31 May 2023

Liddell Future Land Use and Enabling Works (SSD-24937520) – Muswellbrook Shire Council comments on Environmental Impact Statement

Reference is made to the *'Liddell Future Land Use and Enabling Works Environmental Impact Statement'* (GHD, March 2023) (EIS) and associated appendices.

Figure 5 – LPS conceptual final landform

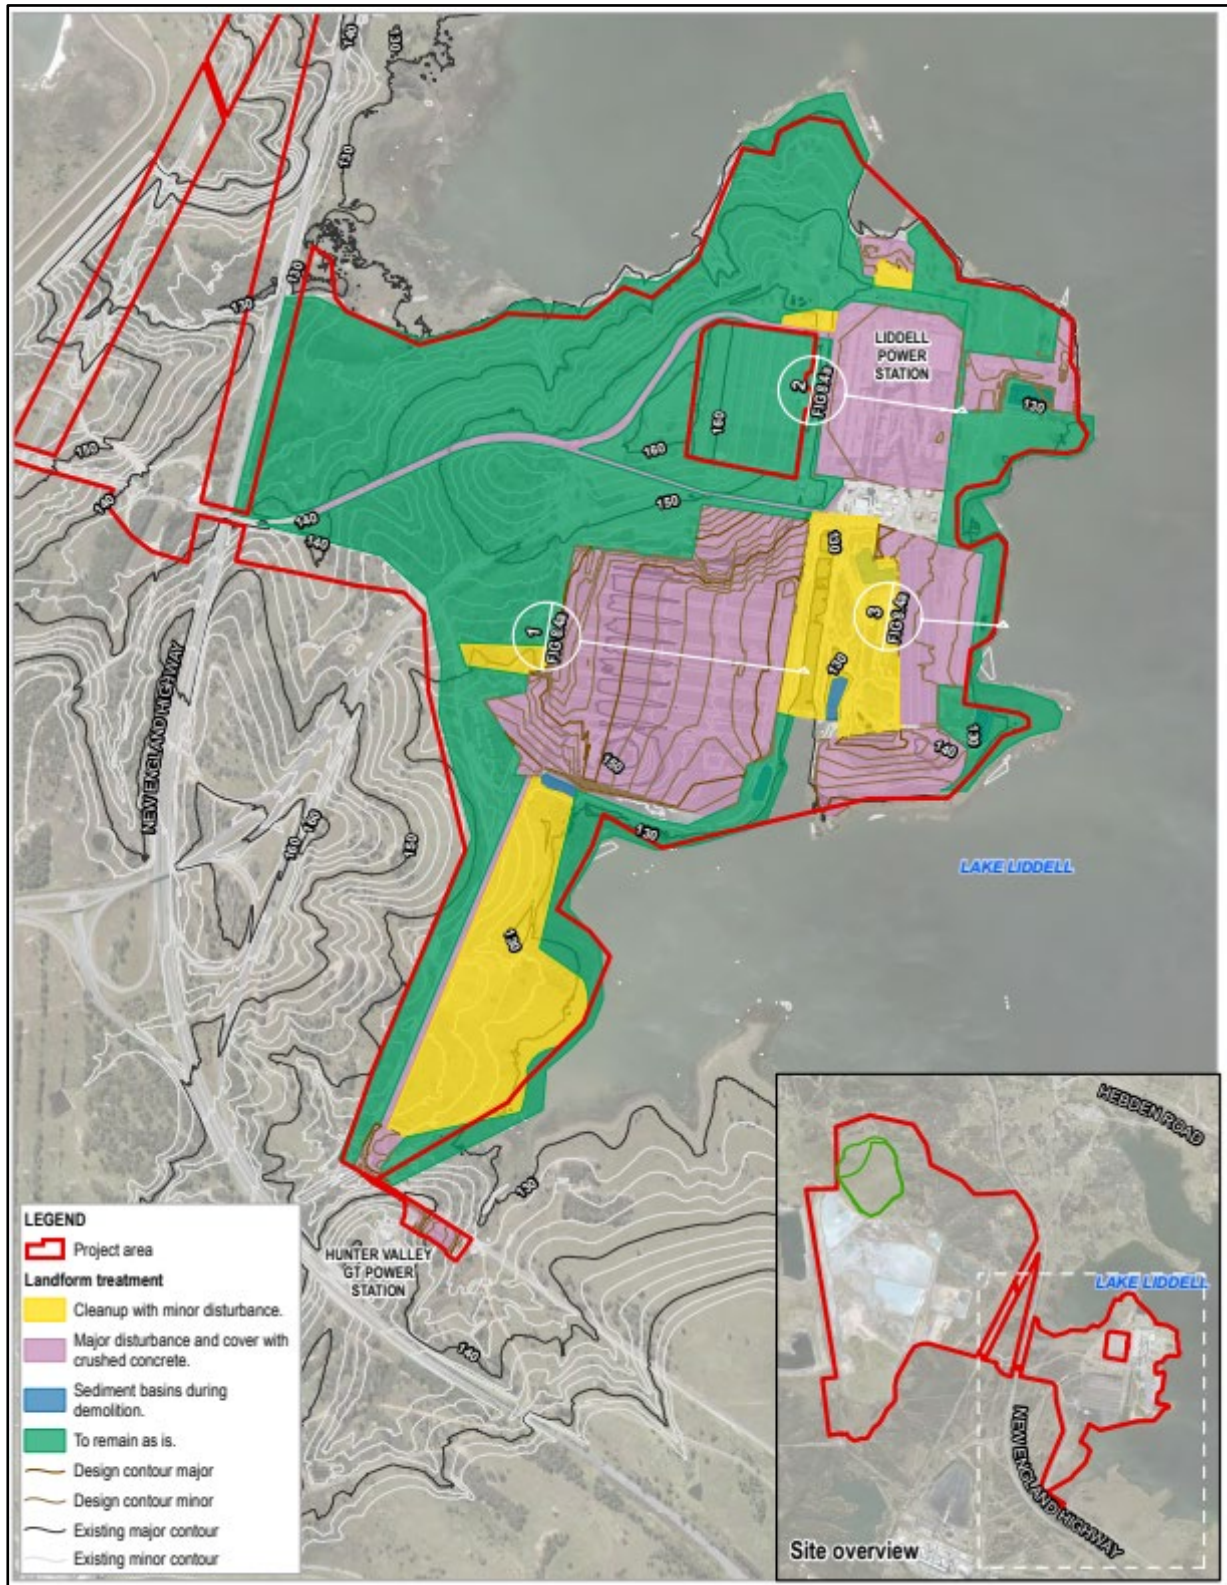
23. Most of the site (except for the borrow area) is a gentle slope. These areas will still require certain design principles (identified in the Rehabilitation Strategy) including a drainage design. The drainage design and final landform contours should be incorporated into site wide masterplan (see Ref 20)
24. As stated in the EIS, the final landform of the Borrow Area is required to have a maximum grade of 16.7% consistent with DA 2011-01.

25. Council is concerned about the potential impacts of using concrete as substrate and require further information on how the following will be managed:
- a) Leaching of contaminants - Crushed concrete may contain contaminants such as heavy metals or residual chemicals from previous use or demolition. Over time, these contaminants can leach into the surrounding soil or groundwater, posing environmental risks.
 - b) Soil pH and nutrient imbalance - Crushed concrete may alter the pH and nutrient composition of the soil, affecting its fertility. This can require additional soil amendments and adjustments to maintain a suitable growing environment;
